Wallerawang Battery Energy Storage System

Response to Submissions

May 2022

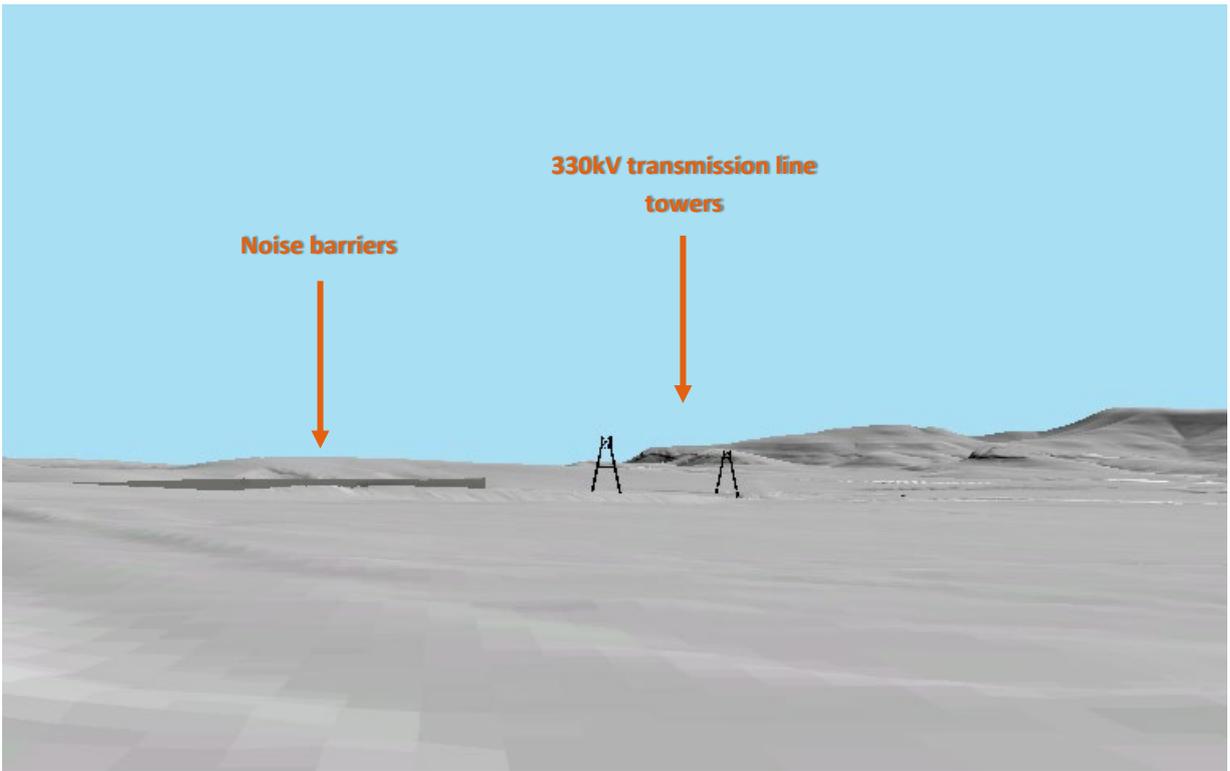
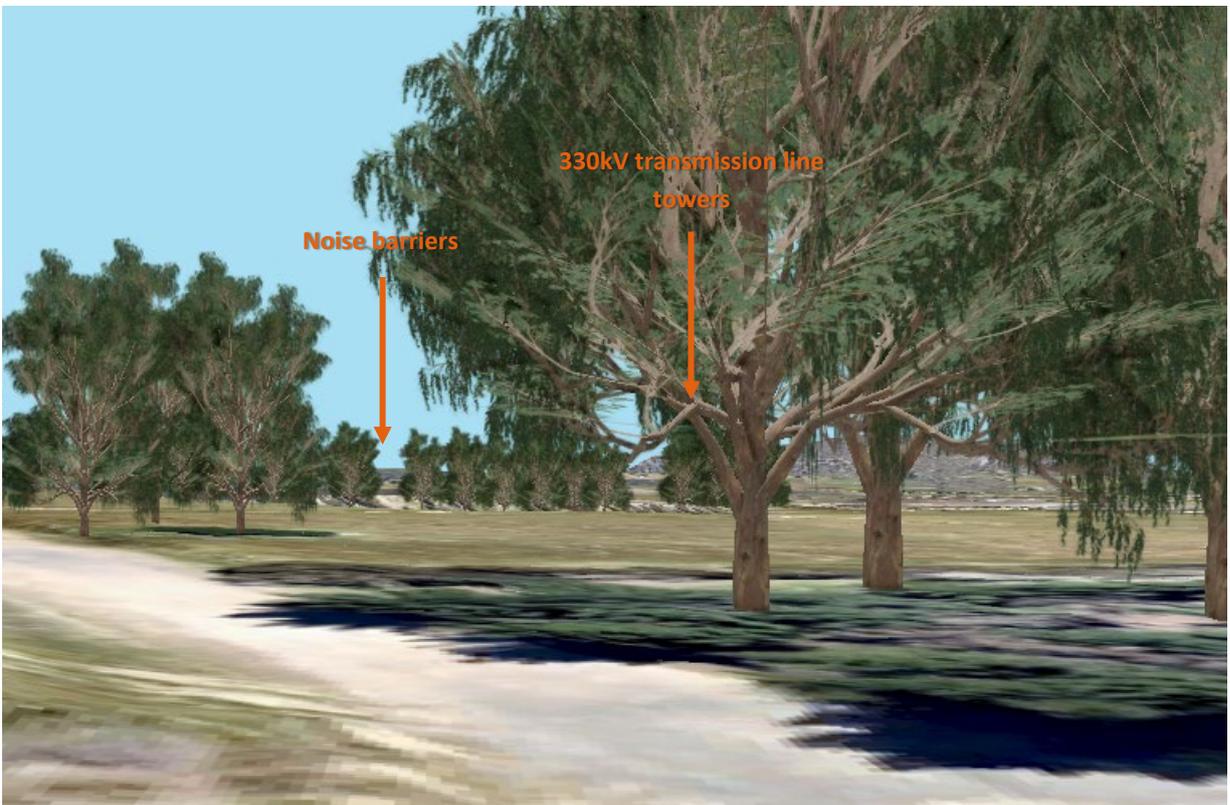
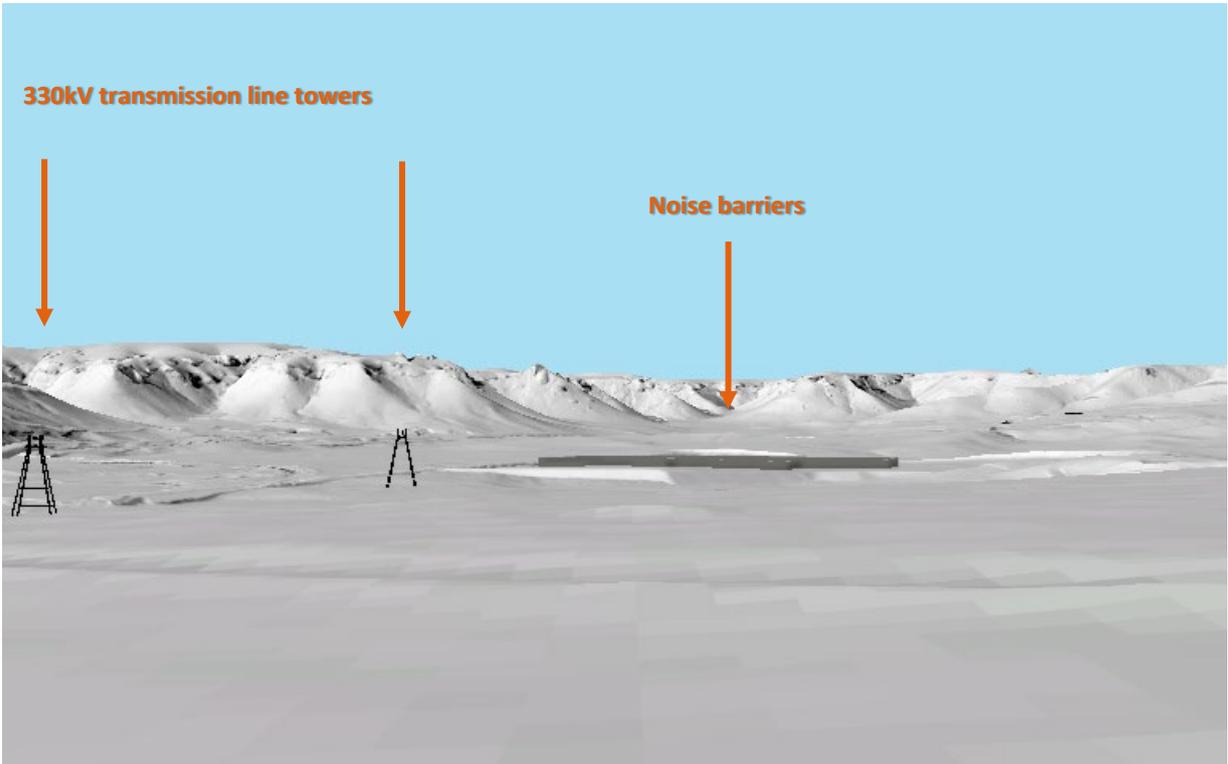
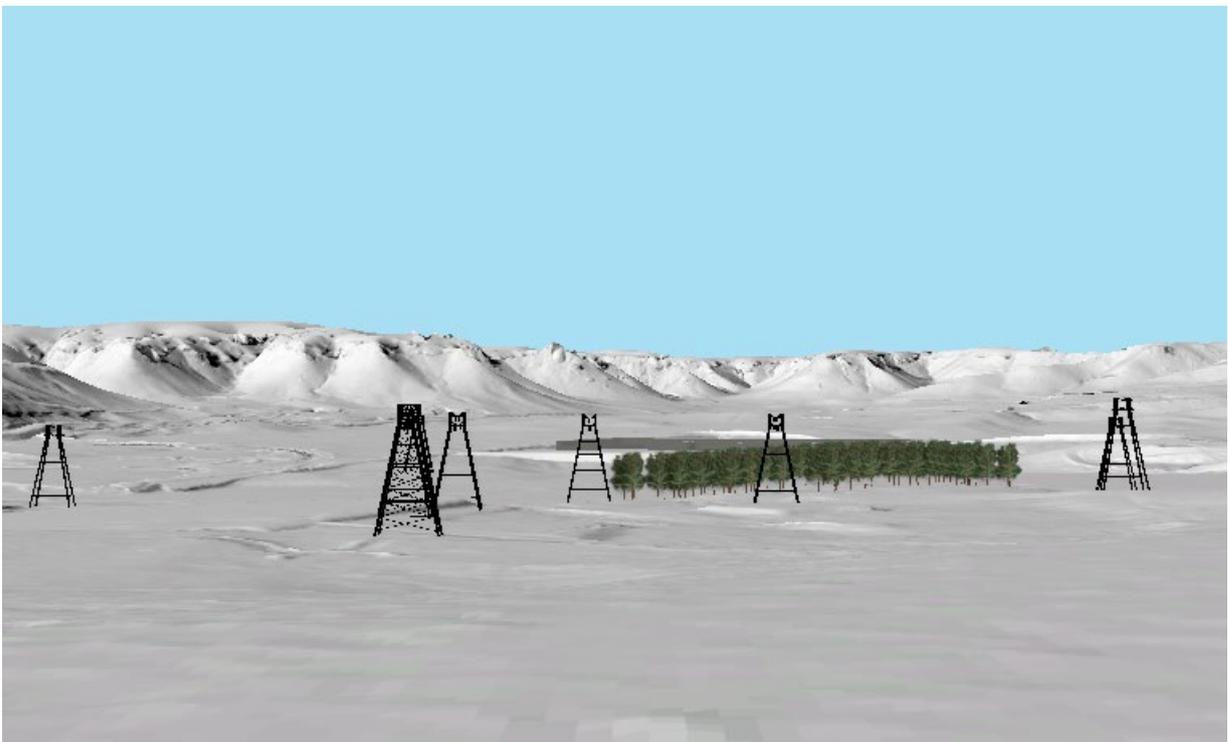
A1.2b	<ul style="list-style-type: none"> Consideration of the combined visual impact of the proposed works with changes to ground levels and proposed 5 m+ high noise barriers; 	The visual impacts of the proposed 8 m noise barriers (as described in the revised Noise Assessment) and the proposed changes to ground levels, has been considered for all viewpoints in the revised Visual Impact Assessment (Appendix D). This has been supported by incorporating the modified terrain and the noise barriers into a 3D GIS model to verify the assessment.	Visual Impact Assessment (Appendix D of this RtS)
A1.2c	<ul style="list-style-type: none"> Images of the proposed Project layout from Viewpoints 1 and 2; and 	GIS based visualisations for the Project from Viewpoints 1 and 2 are included in the Visual Impact Assessment (Appendix D).	Visual Impact Assessment (Appendix D of this RtS)
A1.2d	<ul style="list-style-type: none"> The selection of Viewpoint 4 as the most representative of residential properties in Wallerawang and consider provision of an additional viewpoint from the eastern boundary of the residential area, including an analysis of visual impacts in the event of the future removal of the interceding pine plantation. 	An additional viewpoint was assessed in the revised Visual Impact Assessment (Viewpoint 7 – from Blaxland Street, Wallerawang). This has considered the harvesting of pine plantations that currently dominate the view from this location. While the harvesting of the pine plantations may allow some elements of the Project to become visible, there	Visual Impact Assessment (Appendix D of this RtS)

No.	Comment	Response	Reference
		will still be substantial intervening vegetation (mature Eucalypts) between the viewpoint and the Project which will limit the Project's visual impact from this location. Any views to the Project Site following harvesting of the pine plantations would be in the context of increased visibility of a range of other existing electrical infrastructure including a number of high voltage transmission lines and the TransGrid 330 kV Substation.	
A1.3	Ensure all site layout plans are consistent, including the EIS site layout plan, the indicative battery layout plan in the Noise and Vibration Assessment and the post-development layout plan in Appendix B of the Water Quality Assessment.	<p>The EIS was based on a preliminary indicative design, while the Noise and Vibration Assessment was based on a layout aimed to show that compliance with the <i>Noise Policy for Industry (NPfI)</i> and how the adopted noise criteria could be achieved.</p> <p>As part of this RtS process, the layout has been refined as a result of further noise modelling was undertaken to address the submissions raised by the EPA. The layout shown in Figure 4 of the revised Noise and Vibration Assessment and reproduced in Figure 7-1 of this RtS, has been prepared based on additional information obtained from a potential battery supplier through the tender process. This layout is similar to what was proposed in the EIS. This is further discussed in Section 7.</p> <p>The layout used in the Water Quality Assessment (Appendix J of the EIS) was the original layout proposed prior to refinement of the construction footprint to avoid the heritage items (i.e. Wallerawang BESS AFT + PAD 01 (AHIMS ID# 45-1-2844) and the sandstone culvert running beneath the former railway alignment. This assessment assumed the BESS facility was 10 ha, the switchyard was 4 ha, and is likely to be a worst-case scenario for the layout.</p>	<p>Figure 4 of the revised NVIA (Appendix A of this RtS)</p> <p>Table 3-6 (Appendix J of the EIS, January 2022)</p>

Wallerawang Battery Energy Storage System
Preliminary Landscape Plan

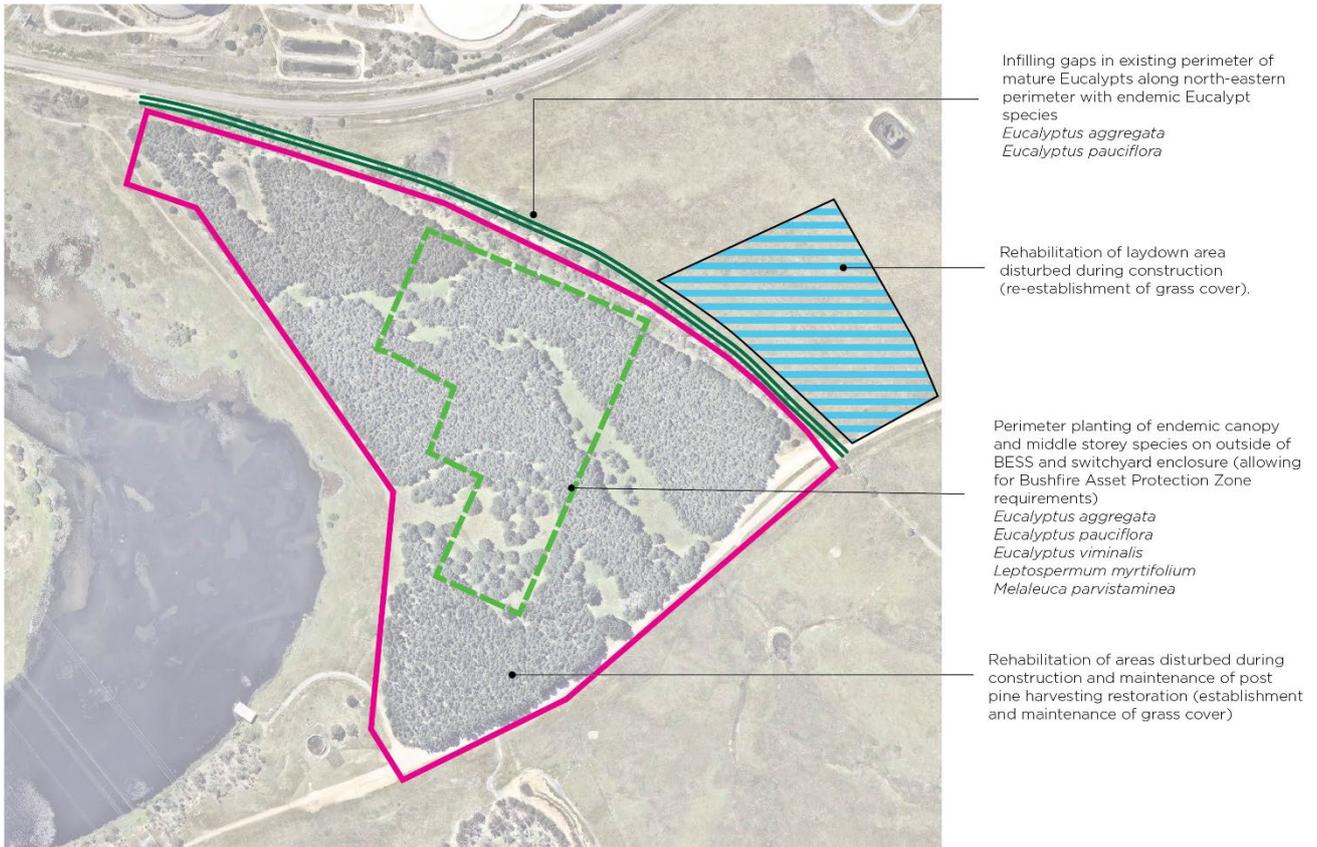
No.	Comment	Response	Reference
		demonstrated that the fire risks from batteries complies with <i>HIPAP No.4</i> .	
A1.2a	<p>Provide further information and clarification in the visual assessment, including:</p> <ul style="list-style-type: none"> A table listing the viewpoints, visual sensitivity, magnitude to visual change, distances and elevation differences; 	A revised Visual Impact Assessment has been provided in Appendix D of the RtS. This includes the addition of a summary table listing viewpoints, distances to the Project, visual sensitivity, magnitude of change and visual impact details and updated viewpoints. Elevation changes are not included as elevation change is not directly relevant to visibility – it is the presence of intervening vegetation, buildings and terrain that is most relevant and these are largely independent of the elevation change between the viewpoint and the Project.	Visual Impact Assessment (Appendix D of this RtS)

No.	Comment	Response	Reference
		An indicative Landscape Plan with indicative planting is included in Visual Impact Assessment in Appendix D.	Table 8-1 Mitigation Measure • V4
A1.6	Provide further clarification of the historical use of the site regarding potential contamination	Based on findings in Section 10.2.2 of the EIS (Arcadis, January 2022), the Project Site was historically used for grazing paddocks, railway and power station infrastructure from the 1820's to 1950's and as a pine plantation from the 1980's. In accordance with SEPP55 and the <i>Managing Land Contamination Planning Guidelines</i> (DUAP, EPA, 1998), the Project Site is not considered to be a contaminated land area due to known historical use of the site and that it has been largely unused for the past 100 years.	Section 10.2.2 of the EIS (Arcadis, January 2022)
A1.7	Confirm the length of the proposed electricity transmission line and the size of the development footprint.	As outlined in Table 4-1 of the EIS (Arcadis, January 2022), the length of the transmission line corridor would be approximately 600 m from the TransGrid Wallerawang 330 kV Substation to the BESS switchyard. The total footprint of the Project Site is approximately 22 ha, with the transmission line corridor covering approximately 3.6 ha. As detailed in item A1.1, the refined layout is estimated to have around 270 enclosures, split up into five groups. Each of the groups is estimated to require a concrete pad of 0.437 ha, therefore a total of 2.2 ha is estimated for the five groups of enclosures. The inverter pad is estimated to be 0.82 ha. The battery facility (including battery enclosures, inverter switchyard and noise barriers) is estimated to be 4.75 ha, which also included the spaces between the battery groups for maintenance and access and spaced between the enclosures	Table 4-1 of the EIS (Arcadis, January 2022) Section 7.1 and Table 7-1 of this RtS
